July 13, 2026

**RE: Review Comment Responses / State Highway 83 & Needles Subdivision
El Paso County, Colorado**

The purpose of this letter is to respond to the CDOT review comments dated June 22, 2026 (1st Review). We have provided detailed responses to the review comments and made revisions to the Transportation Memorandum. We remain available to discuss further if needed. The following is a summary of comment responses:

**Figure 6**  
**TOTAL TRAFFIC - YEAR 2028**  
Volumes & Intersection Geometry  
AM / PM Peak Traffic Hour  
(ADT) : Average Daily Traffic

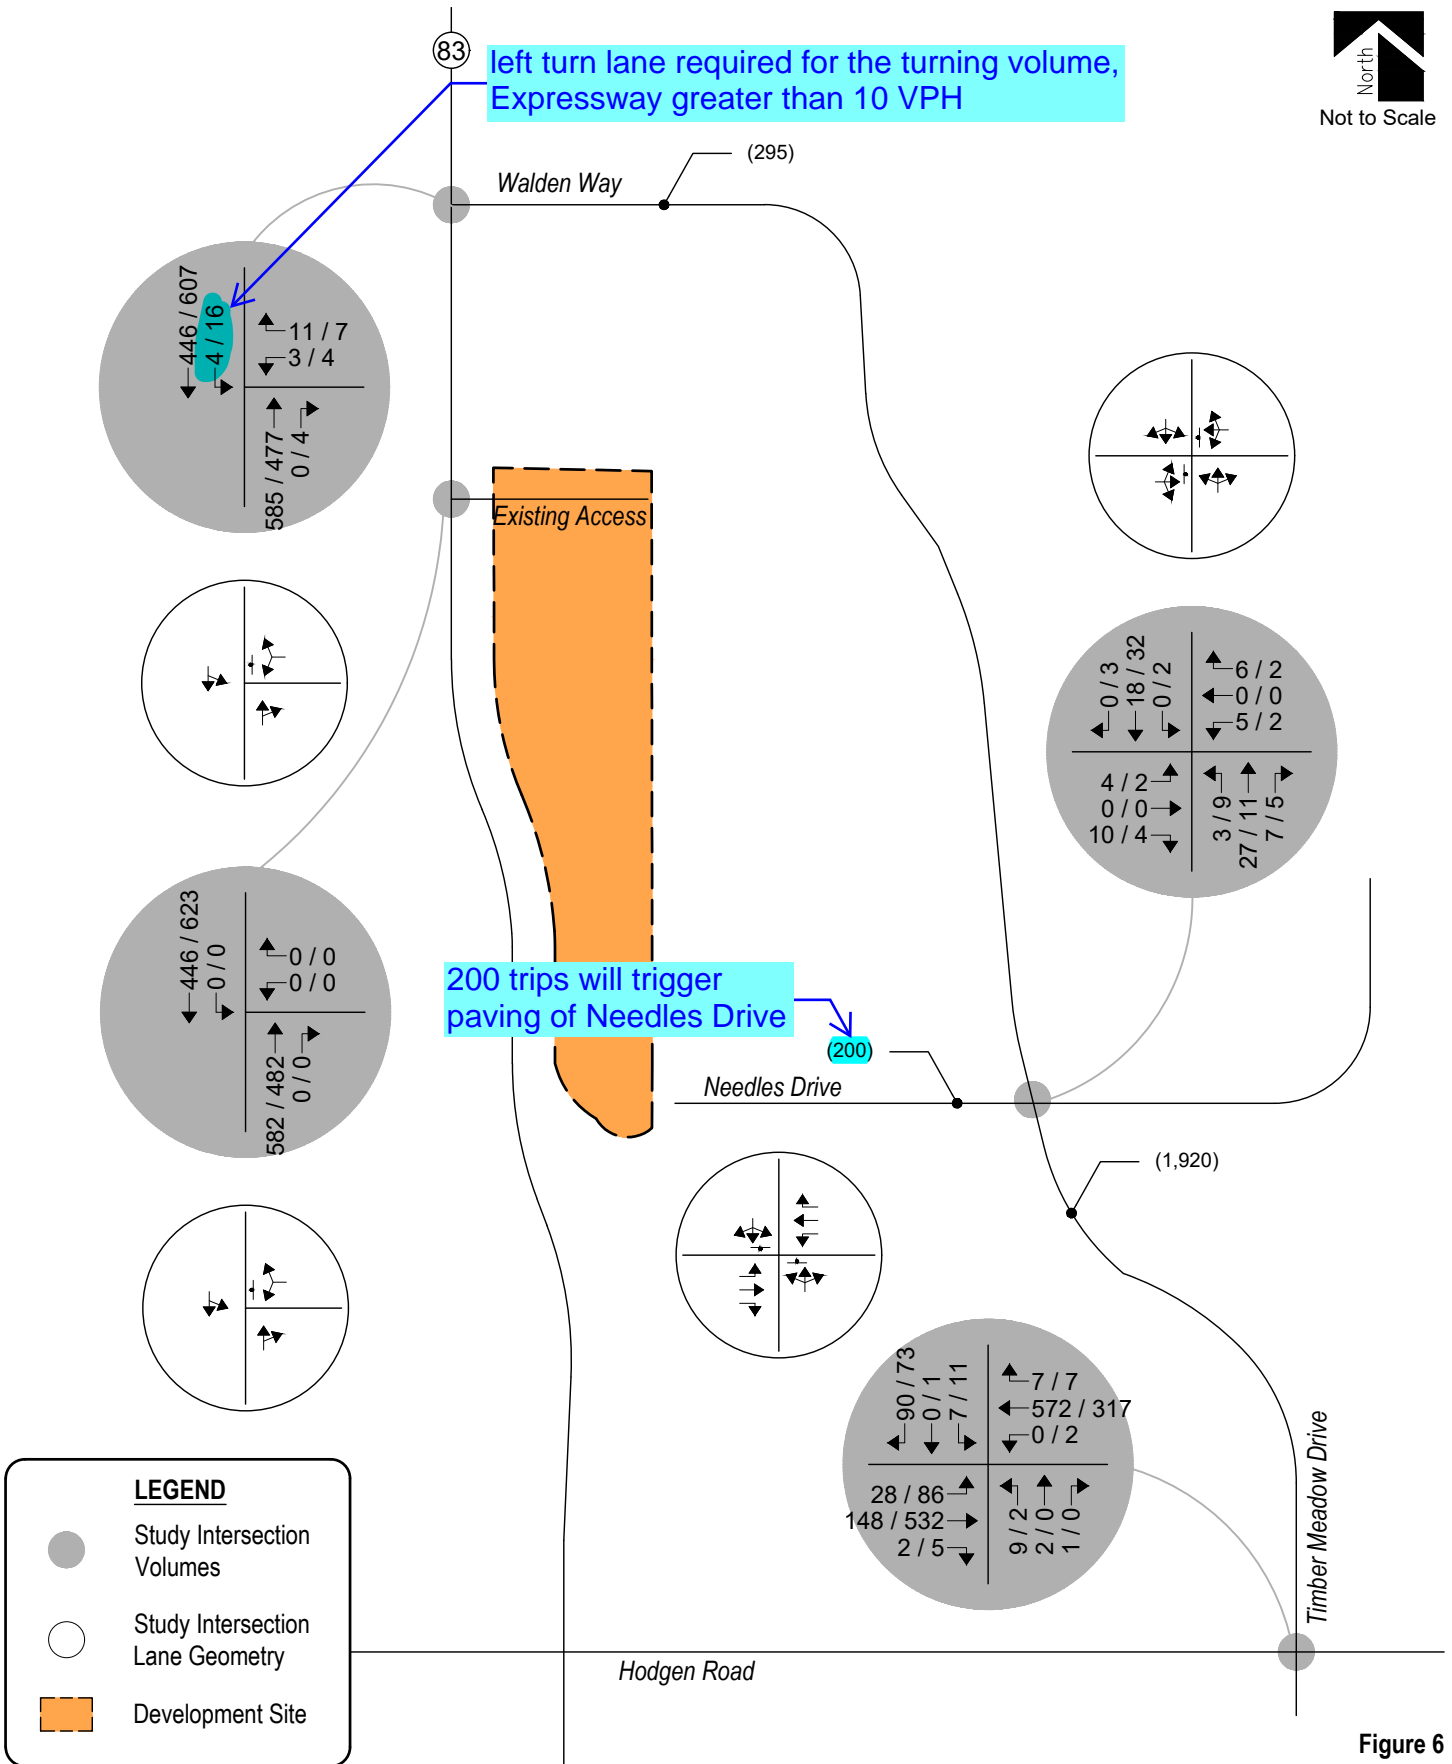
Traffic Comment 1: Please update the Traffic Impact study to include an auxiliary turn lane assessment for Walden Way.

Comment Response: Auxiliary lane discussion added.
